DOC17/20272-02, File No. EF13/3519

**RIX'S CREEK EXTENSION PROJECT SSD 6300
ADDENDUM RTS-MAIN REPORT**

I refer to your email dated 16 January 2017 in respect of Rix's Creek Extension Project SSD 6300 and the document titled "*Rix's Creek Continuation of Mining Project Response to Submissions Addendum*" dated 21 December 2016 prepared by AECOM ("Addendum RTS").

Figure 3: Predicted 24-hour average PM₁₀ concentrations for Receptor 45 in Year 2017 and 2020

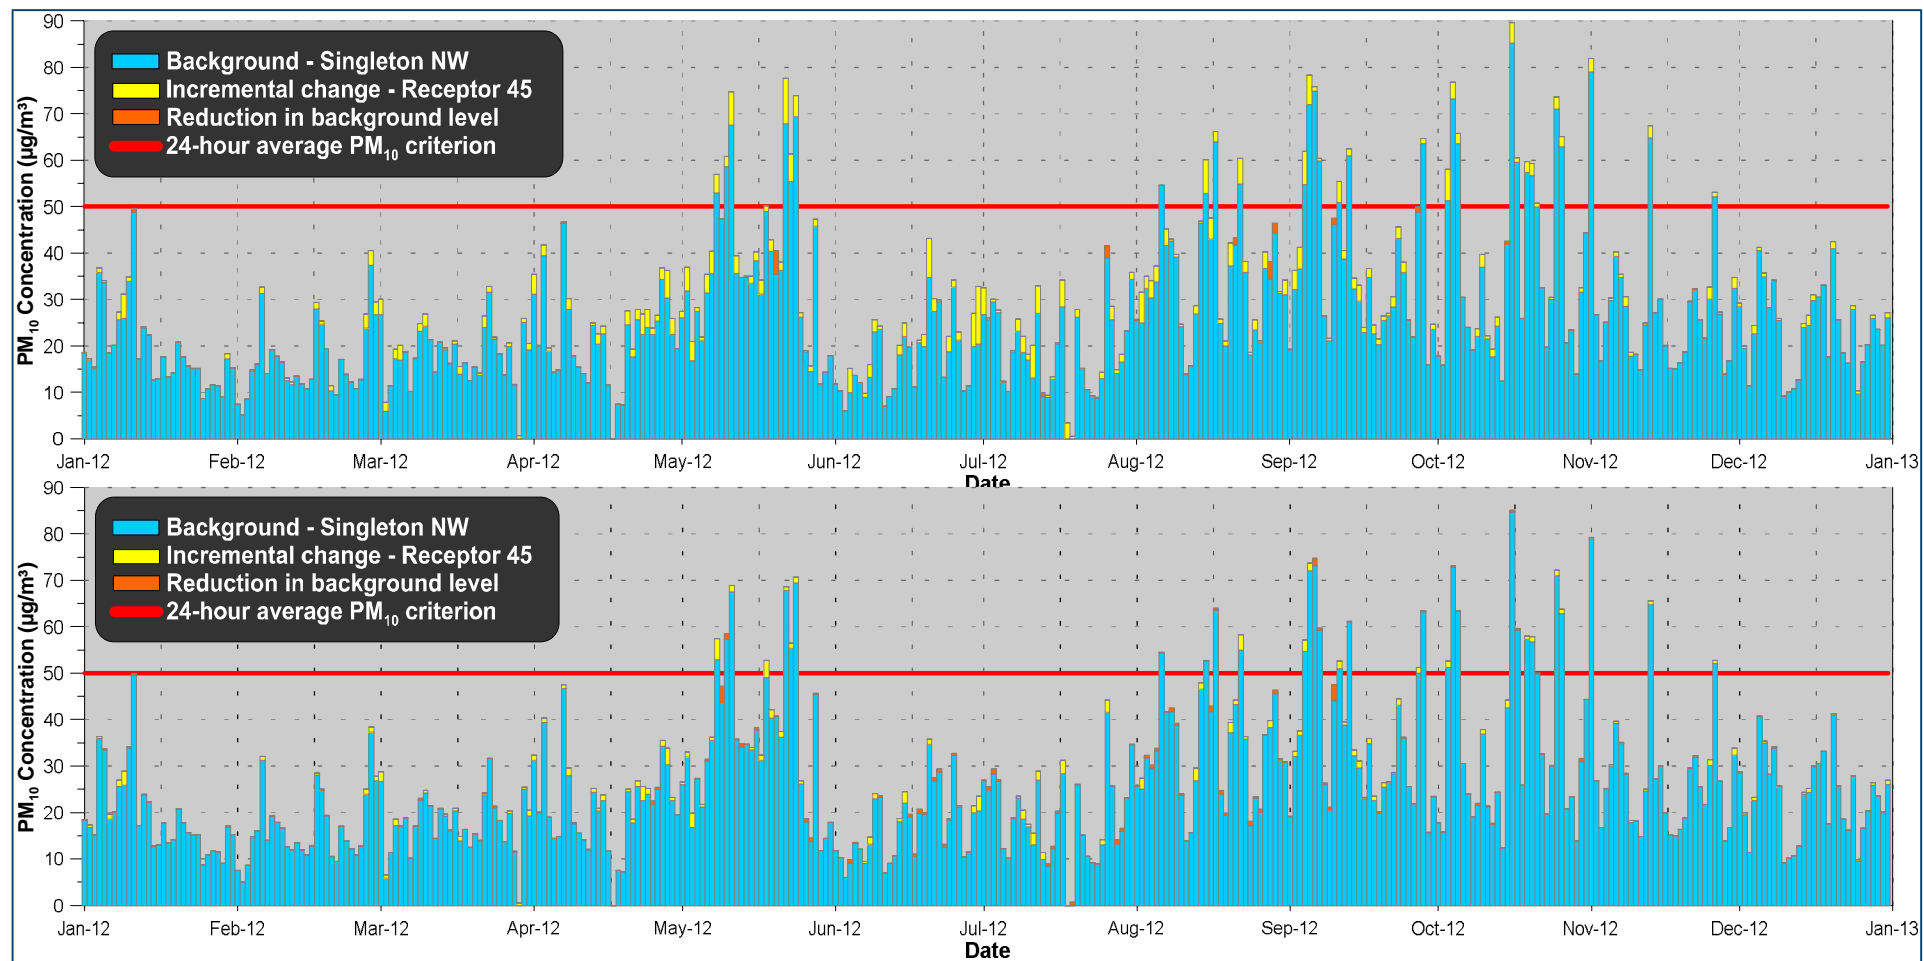
As noted in our previous advice Table 6 in Appendix D to the proponents RTS lists additional exceedances of the 24-hour PM₁₀ criterion for receptor 45 in years 2020 (1), 2023(4) and 2026(3). No evaluation of additional exceedances is provided for nearby receptors such as 40-43, 46, 48, 49, 54,

Figure 4: Predicted 24-hour average PM₁₀ concentrations for Receptor 45 in Year 2023 (reduced schedule) and 2026

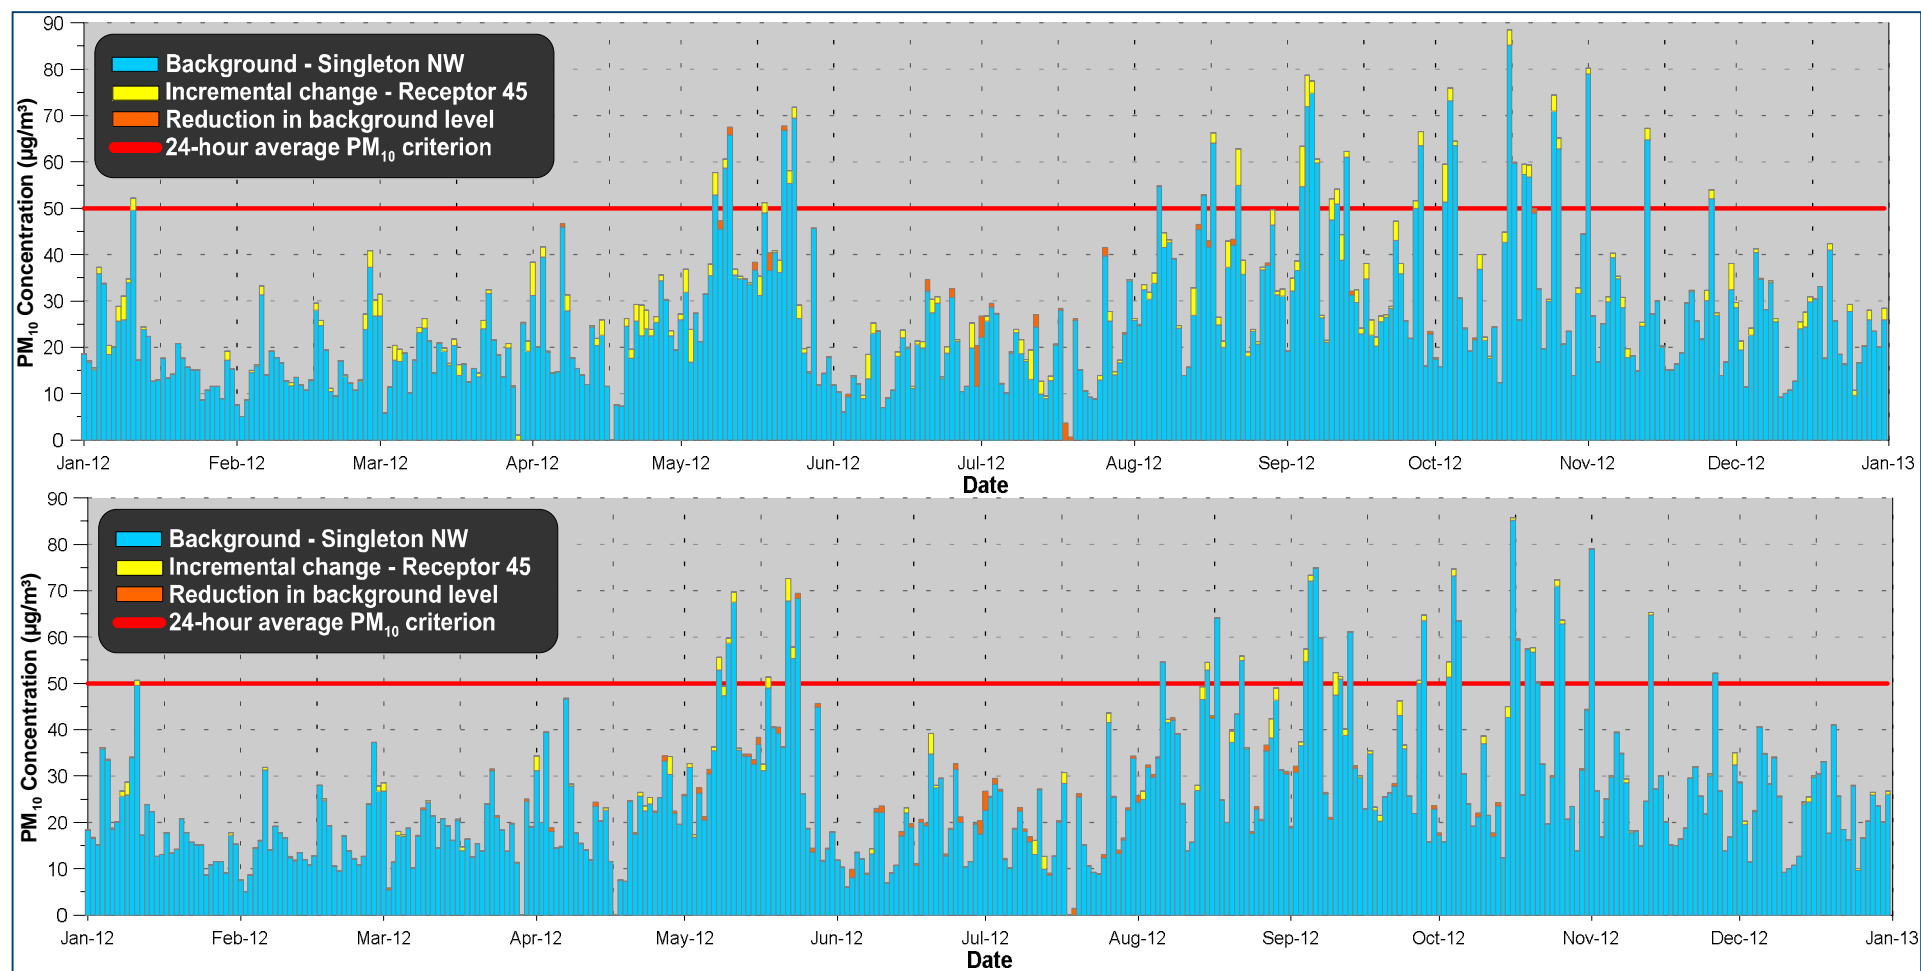
The EPA note however that following acquisition of the Integra Mine, production from Rix's Creek extension can reduce by 25% in the years 2021 to 2025. A detailed assessment of this reduction has not been submitted. Further the EPA is not aware of a significantly amended mine plan or an amendment to the proposed maximum production associated with the proposal.
